RECOMMENDATION FOR PLANNING AND DEVELOPMENT COMMITTEE

APPLICATION REF: 3/2025/0945

PROPOSED SINGLE STOREY SIDE AND REAR EXTENSION AT 4A WISWELL LANE,
WHALLEY, BB7 9AF

7302 - P01

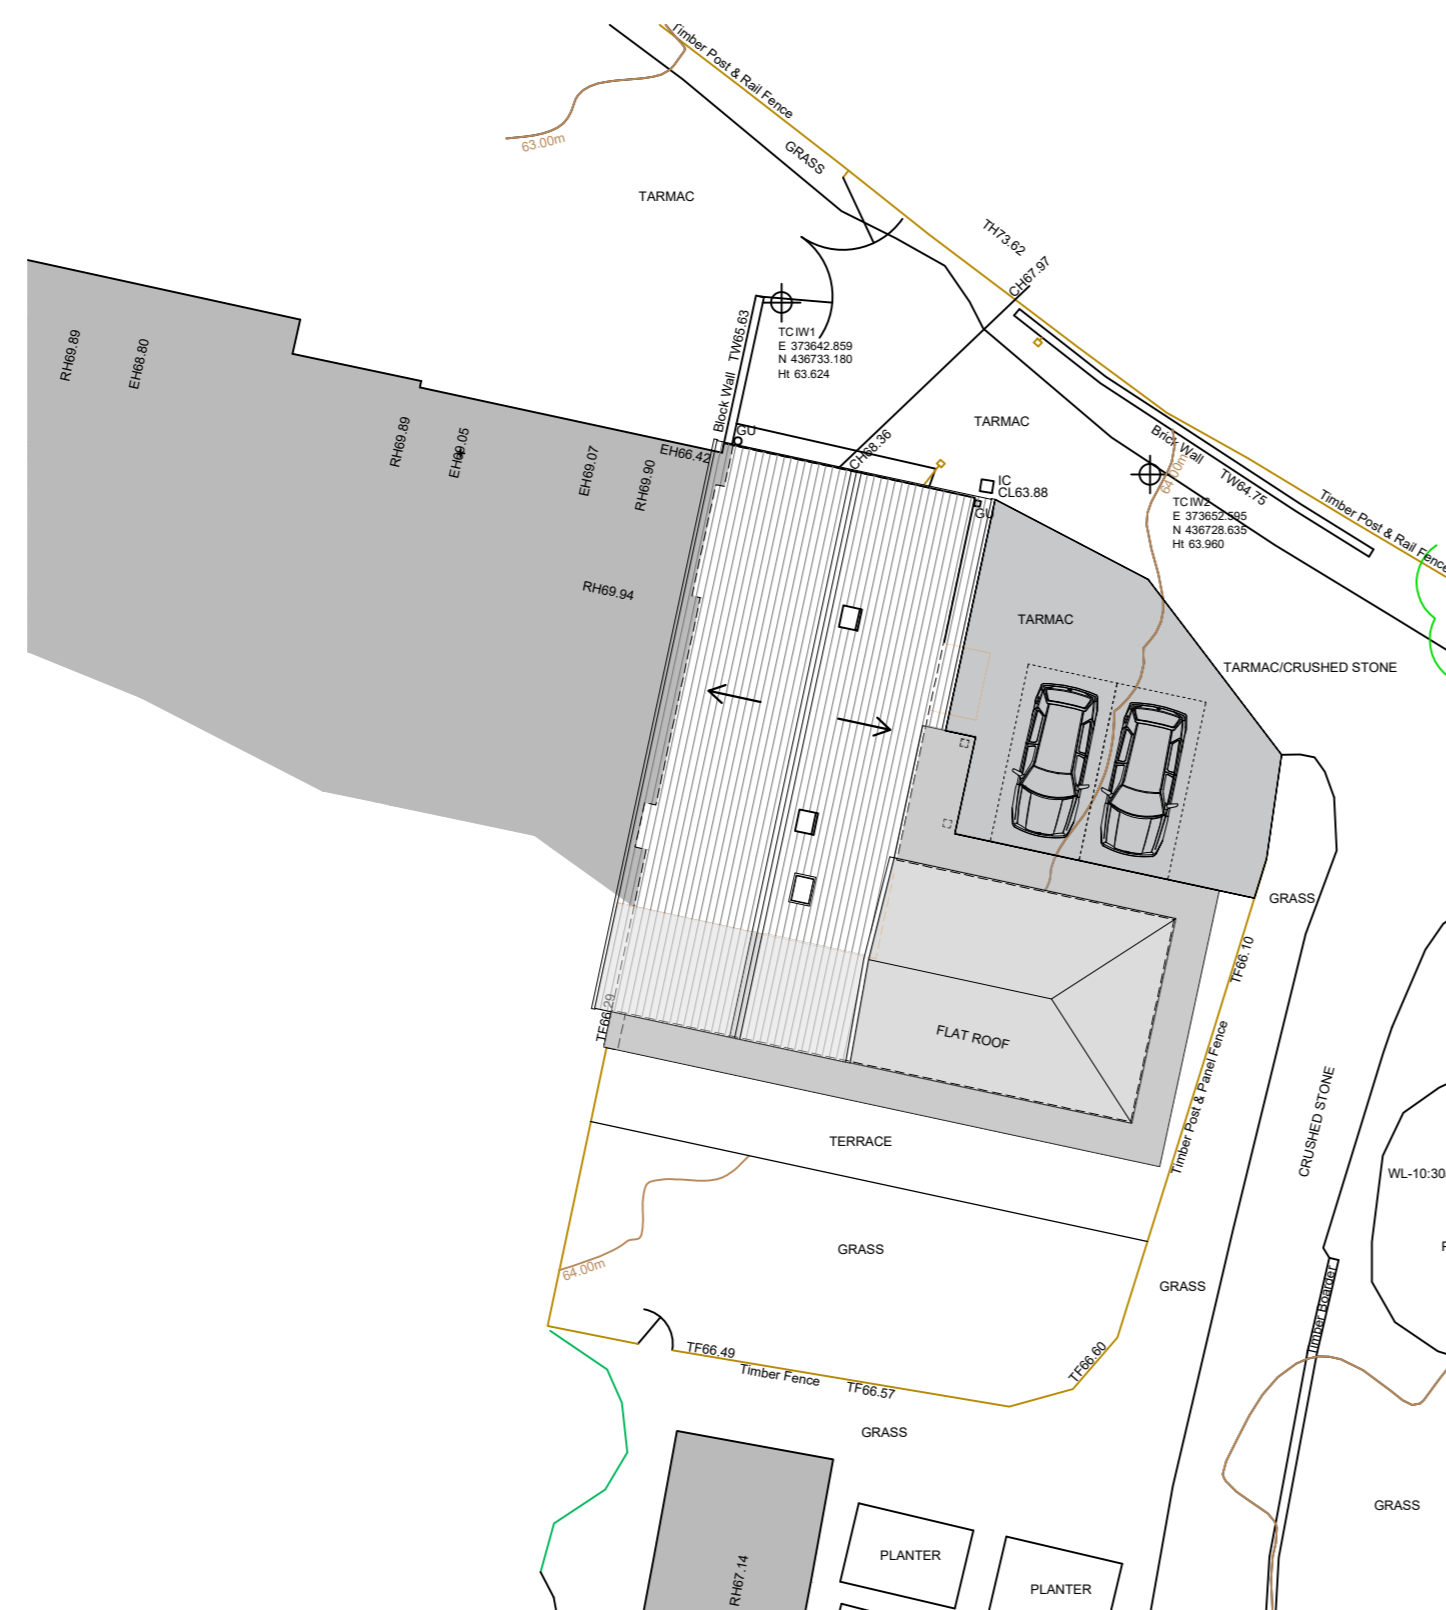
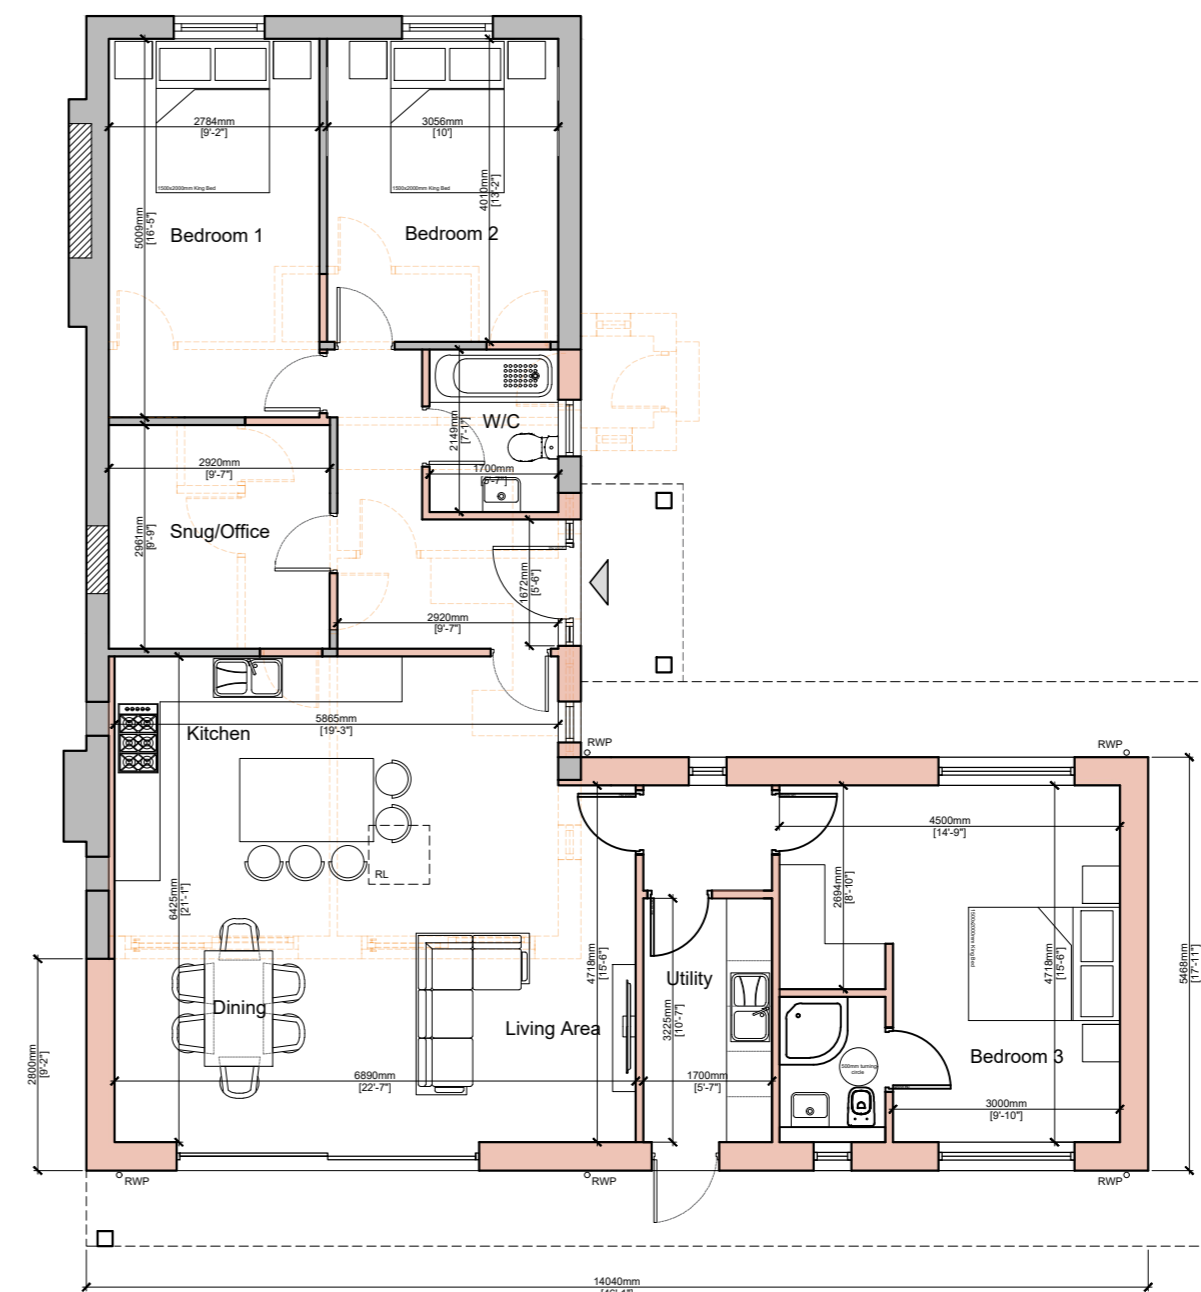
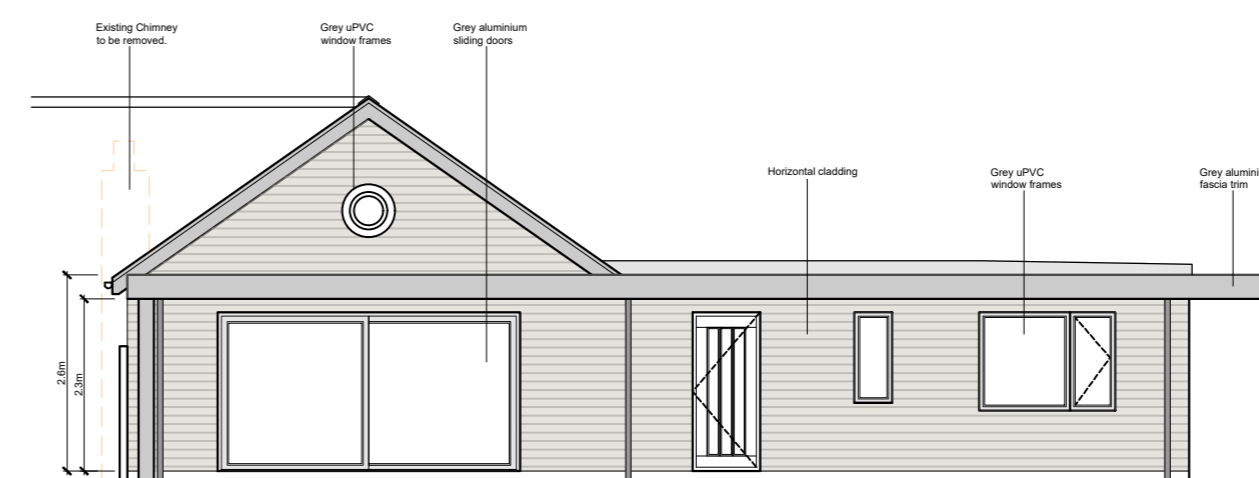
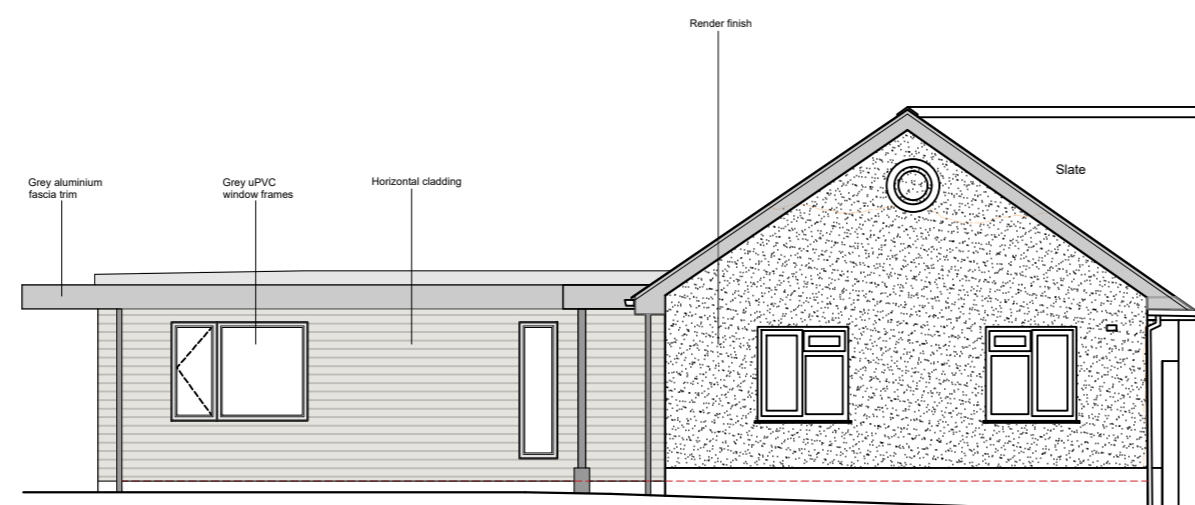
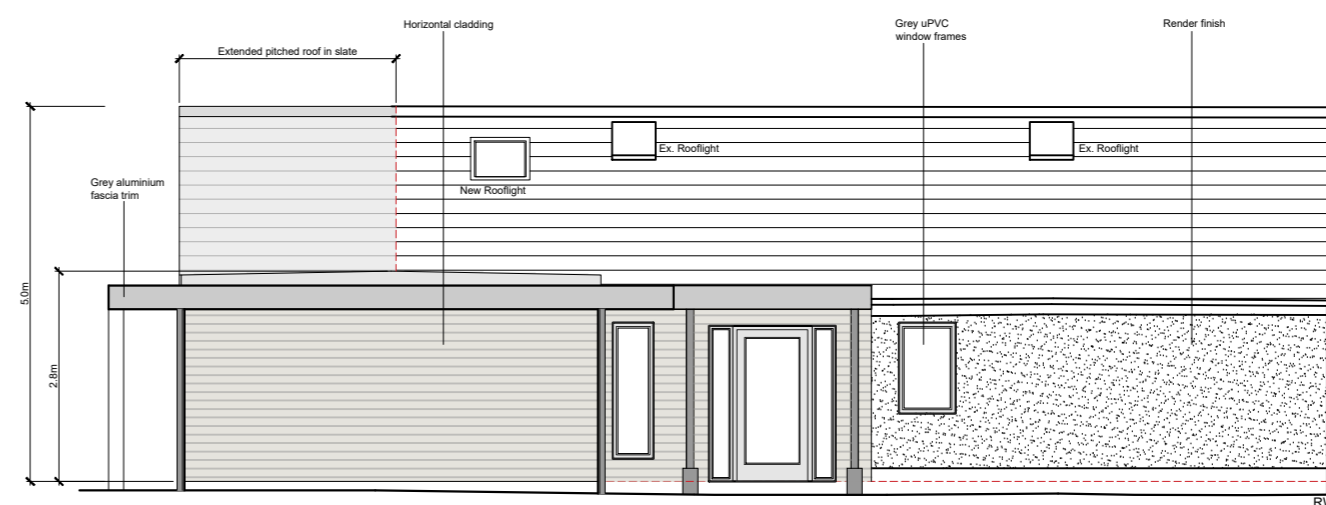
- 5.2.3 No.4 Wiswell Lane benefits from an existing window opening adjacent to the shared boundary with the application property, which is understood to serve a habitable room, as well as a substantial rear extension towards the western extents of the property. As such, concerns were initially raised with respect to the further rearward extension of the application property and the subsequent loss of light upon the aforementioned neighbouring window.

- 5.3.1 The scheme originally submitted with the application included a fully clad, flat roof side extension measuring 8m by 5.5m. However, the overall size and design of the proposal was considered to appear unsympathetic and discordant when viewed in context with the existing built form of the application property and neighbouring residential properties.
